KITTTITAS COUNTY COMMUNITY DEVELOPMENT SERVICES

RE: VA-22-00002 Heidt – Deemed Incomplete and Request for Additional Information

Kittitas County Community Development Services (CDS) received your Zoning Variance Application on February 24, 2022 to reduce the front setback from Pinnacle Lane on the north property line down to 10 feet for a house and down to 5 feet on the southwest side property line for a new garage. The definition for a Front Lot Line in Kittitas County Code (KCC) 17.08.370 states "*Lot line, front*" means a lot line that abuts any public street, private street, right-of-way or other means of vehicular access, other than an alley." The definition for a Yard Front in Kittitas County Code (KCC) 17.08.590 states: "*Front yard*" means any yard abutting a public or private street. The subject property is zoned Rural Recreation. Pinnacle Lane, a private road, has a Front Yard setback of 25' pursuant to KCC 17.30. This parcel is located at 1031 Pinnacle Ln, in a portion of Section 04, T19, R15, WM in Kittitas County, bearing Assessor's map number 19-15-04054-0013. I have enclosed a map of lot lines and required setbacks. Your application has been determined incomplete a

ATTACHMENT 2

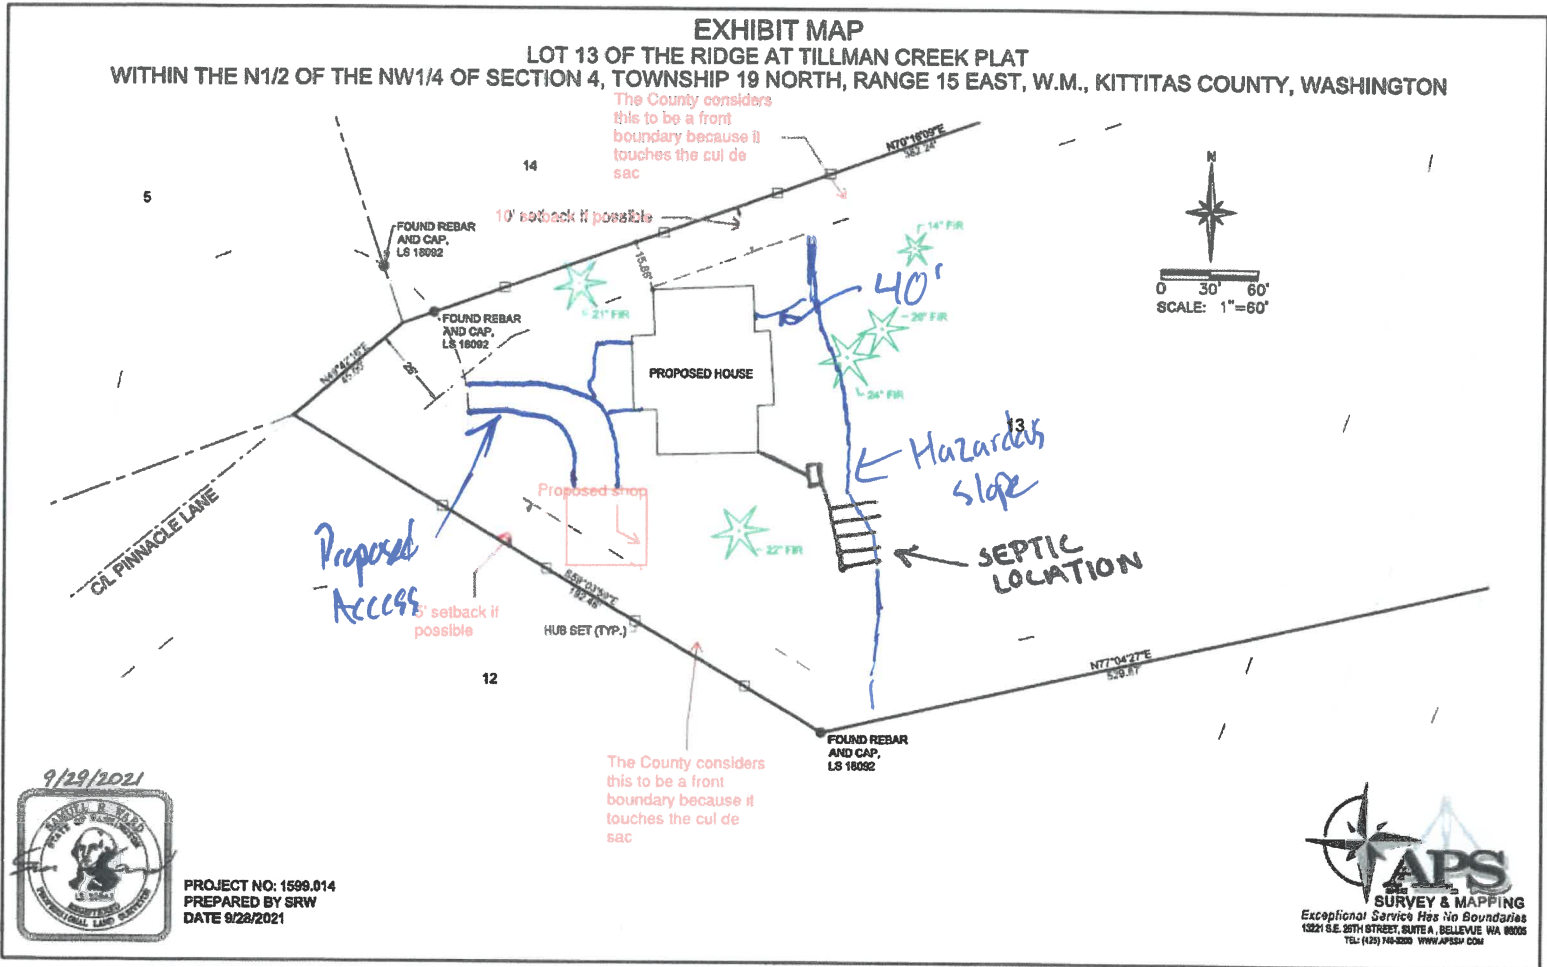
1. In relation to KCC 15A.03.030, please provide an updated site map that shows all setbacks from existing and proposed structures along with all other site map requirements including but not limited to access to the house/garage and any hazardous slopes.
